WEST SUSSEX COUNTY COUNCIL CONSULTATION

TO:	Arun District Council FAO: Amy Myer
FROM:	Stephen Gee WSCC - Highways Authority
DATE:	1 October 2020
LOCATION:	Chalcroft Nursery, Chalcroft Lane, Bersted
SUBJECT:	BE/81/20/OUT Outline application with some matters reserved for the development of 20 residential dwellings, 2,240 sqm of commercial space (Use Class A1, B1(b) B1(c) and B8)
DATE OF SITE VISIT:	n/a
RECOMMENDATION:	No Objection / Further Information
S106 CONTRIBUTION TOTAL:	TBC

This is the 2nd response as is provided following consideration of TN ref ITB14224-011 title Response to WSCC and HE representations.

APPENDIX 3
SITE ACCESS PLAN (REF: ITB14224-GA-001 REV B)

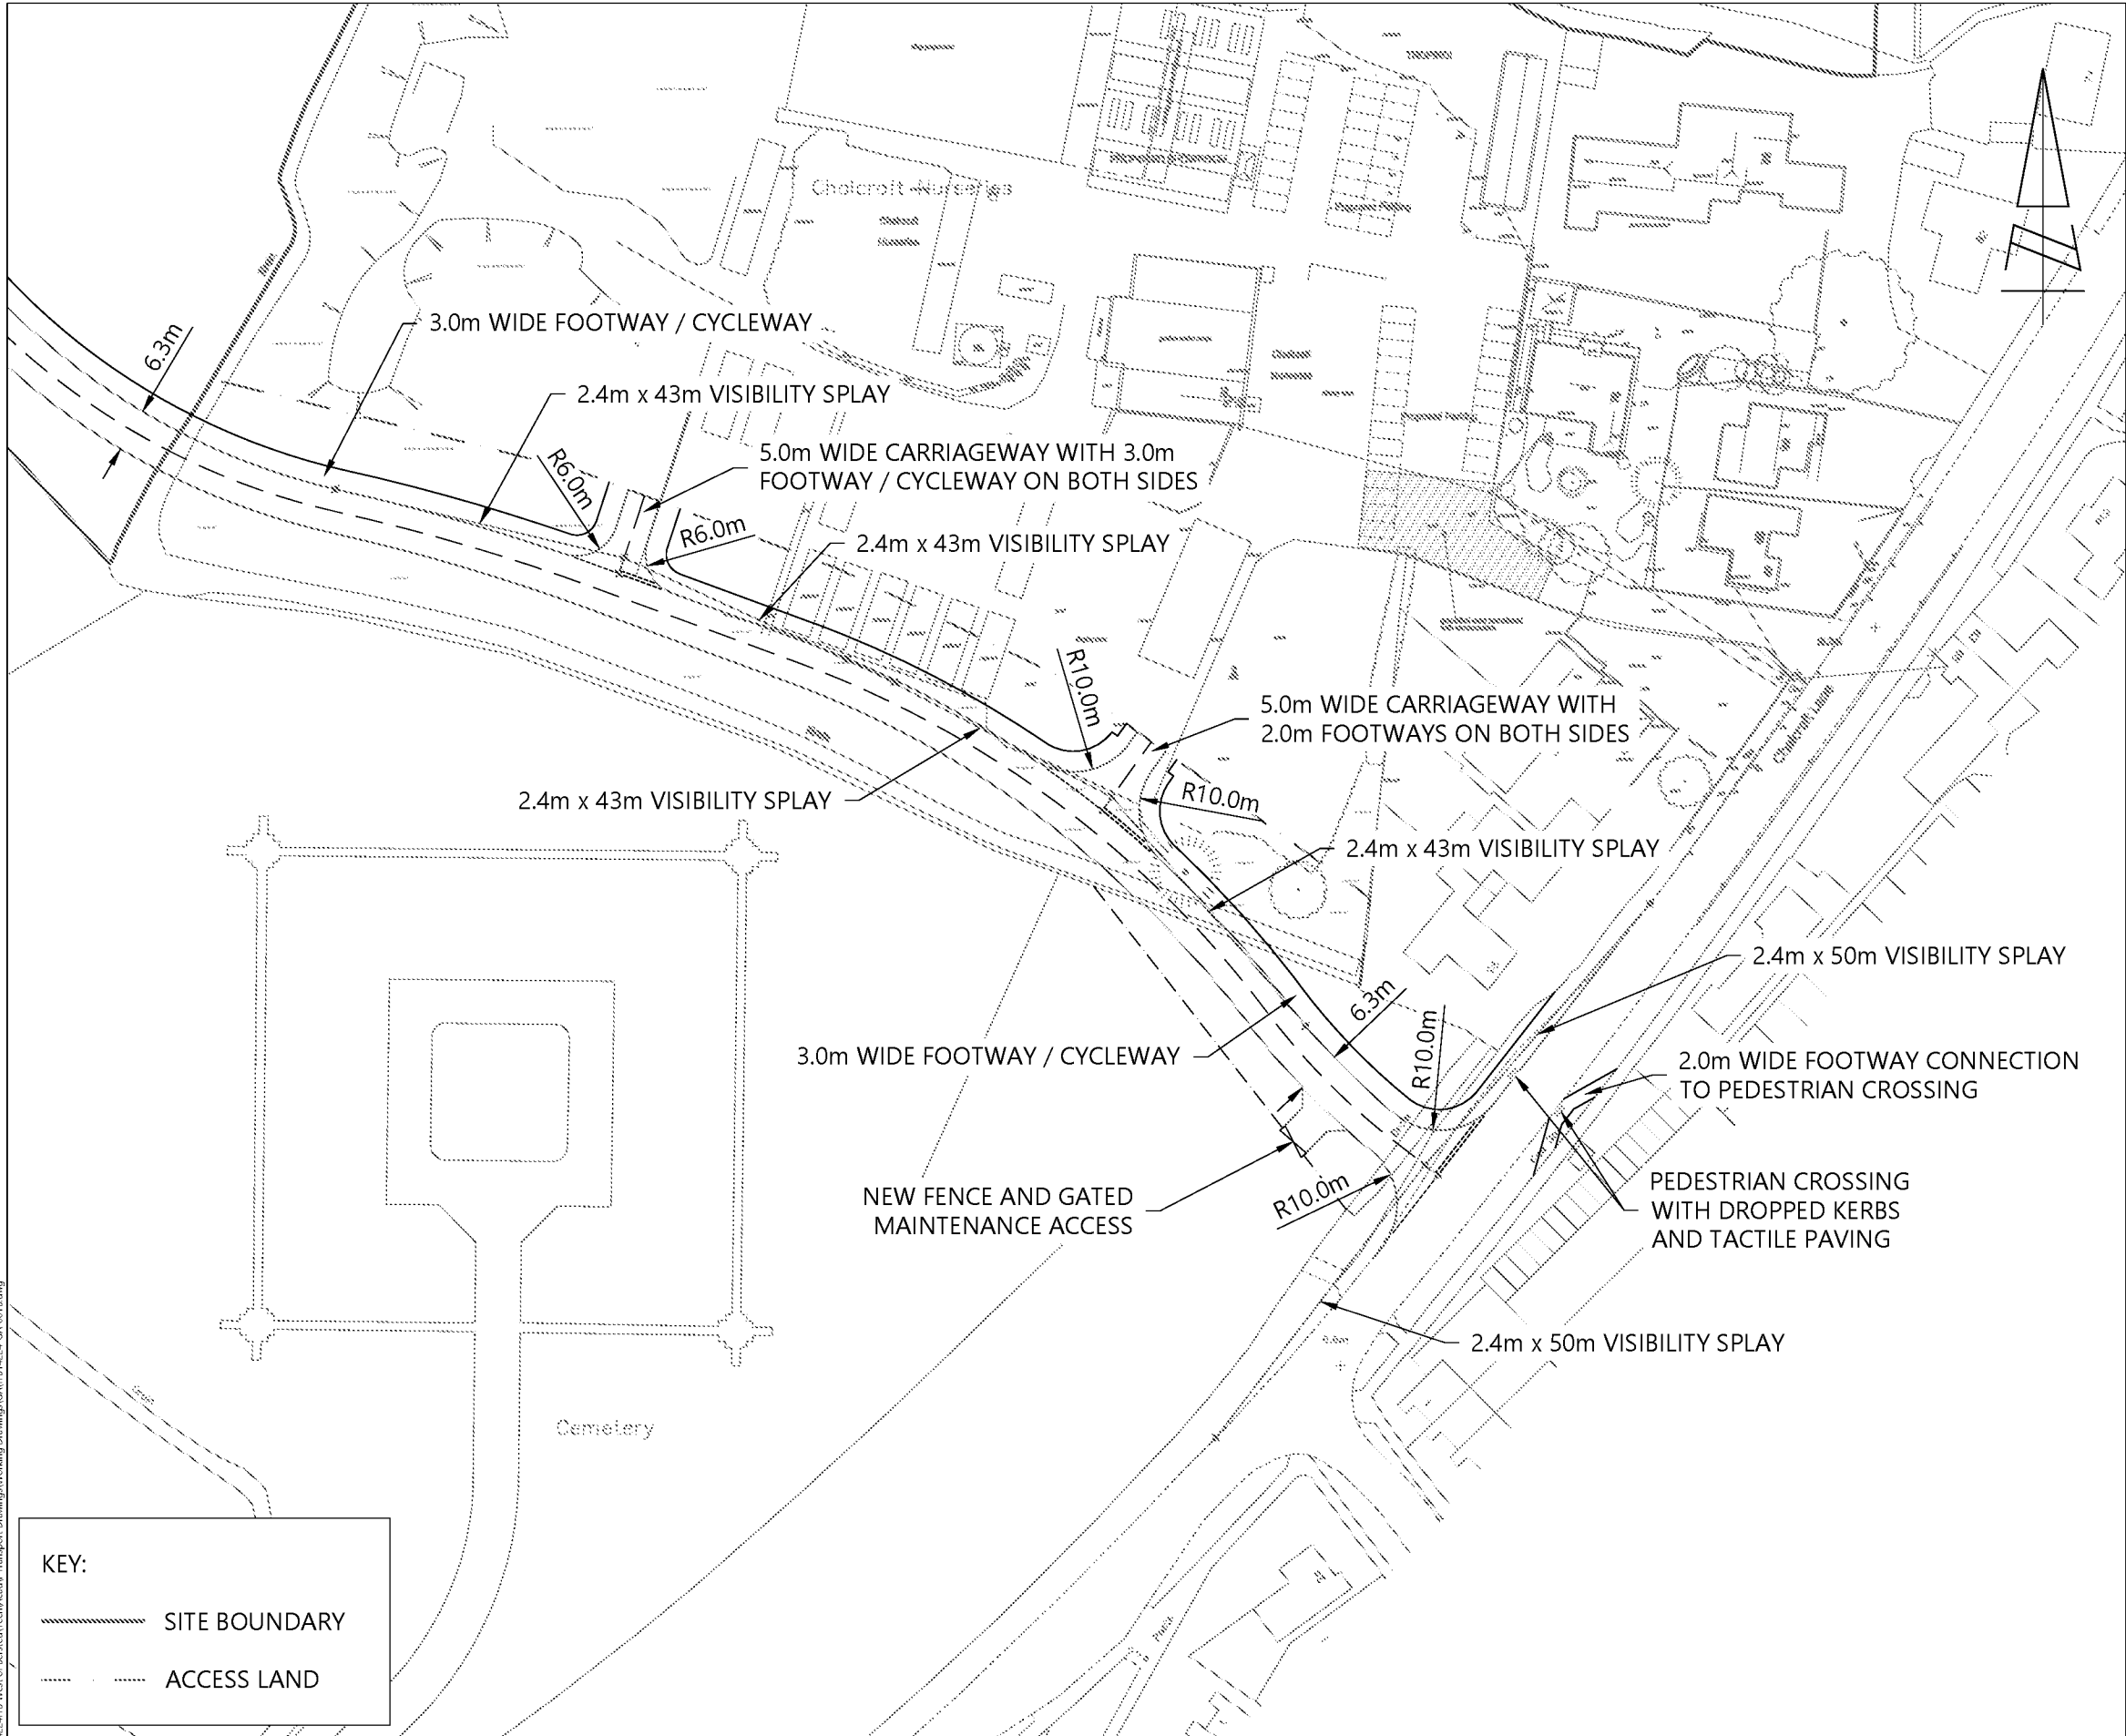
Consideration has been provided for the provision of a Ghost Right Hand Turn Lane, It should be noted that the AADT of Chalcraft Lane is in excess of 16,000 vehicles and the AADT of the site access would be excess of 300 vehicles the level where one should be considered (and not 500 as suggested by the applicant).

Given the forward visibility presented and junction modelling the site access proposals as shown in drawing ref ITB14224-GA-001 rev E would be acceptable to the highway authority to serve this application, further information and agreement would be required to ascertain if a ghost right hand turn lane is required for any wider allocation to be served via this access.

No part of the residential development shall be first occupied until such time as the vehicular access serving the development has been constructed in accordance with the details shown on the drawing titled site access arrangement and numbered ITB14224-GA-001 Rev E.
